**Hydro Kurri Kurri Aluminium Smelter Remediation-Mod-1
(SSD-6666-Mod-1): Additional Information**

Table 1: Response to Agency Comments on SSD 6666 Modification 1

**Figure 2 |** Proposed location of leachate management infrastructure

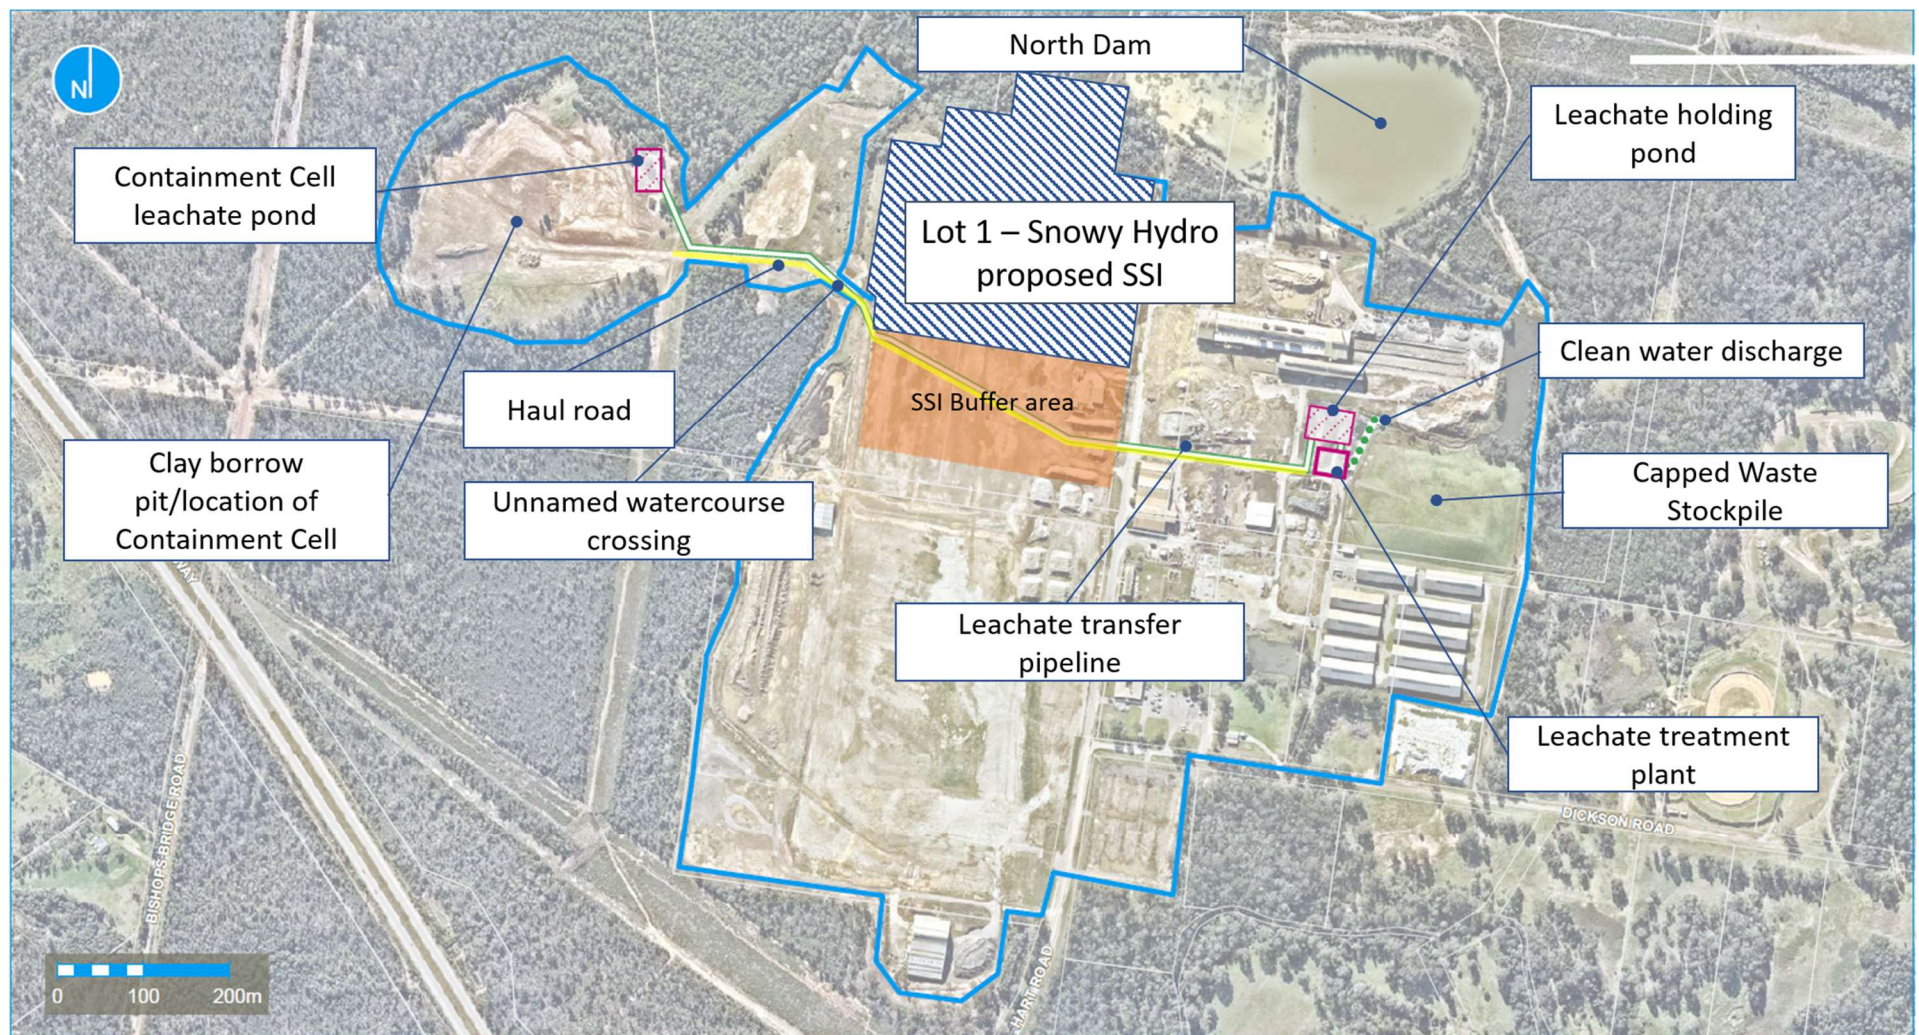
Agency Comments	Hydro Response
<p>Department of Planning, Industry and Environment</p> <p>Diagrammatic representation of the proposed infrastructure (understood to be the revised Figure 3.2)</p> <p>The time period for operation of the TWTP infrastructure (both maximum and expected duration)</p> <p>A direct comparison between the proposed and original approved infrastructure, noting the leachate ponds approved under SSD 6666</p> <p>Details of the route of the pipeline between the Containment Cell leachate pond and the TWTP, including how it would interact with and impact the Hunter Power Project site buffer lands and the remediation haul road</p>	<p>As noted by the Department, the revised Figure 3.2 shows the locations of the proposed Temporary Water Treatment Plant (TWTP) and associated infrastructure. This revised figure is attached.</p> <p>Attachment 1 is a revised version of Section 3 (Modification Description) from the Statement of Environmental Effects (SEE). This has been revised to address this and other relevant comments below.</p> <p>Section 3.6.4 of the Modification Description has been revised to describe the duration of the TWTP operation.</p> <p>Attachment 2 shows the location of the TWTP infrastructure as approved under SSD 6666, and those proposed by Modification 1.</p> <p>The proposed location of the Containment Cell Leachate Pond and the Leachate Holding Pond are consistent with the locations shown in Appendix 1 of the development consent for SSD 6666. The proposed location of the TWTP is approximately 110 m to the east of the conceptual location shown in Appendix 1 of the development consent for SSD 6666.</p> <p>The revised Figure 3.2 shows the pipeline route. Attachment 2 (previously submitted to the Department) also shows the pipeline route and its relationship to the property (Lot 1) that would contain the Hunter Power Project.</p> <p>Section 3.5.2.2 of the Modification Description has been revised to describe how the pipeline would interact with the Hunter Power Project site buffer lands and the remediation haul road.</p>

<p>Department of Planning, Industry and Environment (Biodiversity and Conservation Division)</p>	
<p>The proposed transfer pipe crosses the proposed location of another major project. An updated route should be identified and assessed for impacts</p> <p>The feasibility of off-site transfer of leachate when significant rainfall is predicted is not clear. Details on how significant rainfall would be predicted, how site and transport operations would be informed of this and how this operation would be managed should be provided. The definition of significant rainfall should be based on the storage capacity of the on-site storage systems.</p>	<p>The pipeline route remains within the approved Project footprint, and immediately adjacent to the Containment Cell haul road that is an inherent component of the approved Project.</p> <p>It is acknowledged that the haul road and pipeline routes cross the State Significant Infrastructure project - Hunter Power Project (Kurri Kurri Power Station) (SSI-12590060).</p> <p>Under a contractual agreement between Hydro and the future landowner (McCloy Group) this area would be dedicated for the duration of the Hydro Remediation Project for the remediation activities (including the haul road and the leachate transfer pipeline).</p> <p>Refer to the revised Figure 3.2 and Section 3.5.2.2 of the revised Modification Description regarding the pipeline route and its management where it crosses the proposed Hunter Power Project site.</p> <p>Off site transfer of leachate for treatment forms part of the approved project, and there are no restrictions under the development consent on when such transfers can occur (such as weather conditions).</p> <p>However, Section 3.8 of the revised Modification Description has been revised to describe the conditions when leachate would be transported for off site treatment.</p>

- It would be located as shown in **Figure 3.2**
- it would be constructed of 100 mm diameter HDPE piping and would be butt welded and surface laid
- Where the pipeline is required to cross an access road (the north-south road) the pipeline would be trenched and backfilled into the road pavement to provide uninterrupted access for road users. The pipeline would be installed at minimum of 600mm below the road surface and backfilled with dust or similar product to provide additional protection over the pipe

- Where the pipe traverses the unnamed watercourse, it would be double skinned: the 125mm external diameter pipe would be placed within a 160mm HDPE pipe for an approximate length of 20 metres. It would cross the unnamed watercourse on the edge of the road crossing and not through the floor of the unnamed watercourse

- The pipeline route would be clearly delineated and sign posted. It would be located outside of the signage and flagged star pickets that delineates the access road and:

- A minimum of one metre to two metres from the delineated northern edge of the haul road between the Capped Waste Stockpile and the Containment Cell access road

- A minimum off 600mm to 850mm from the delineated northern edge of the Containment Cell access road
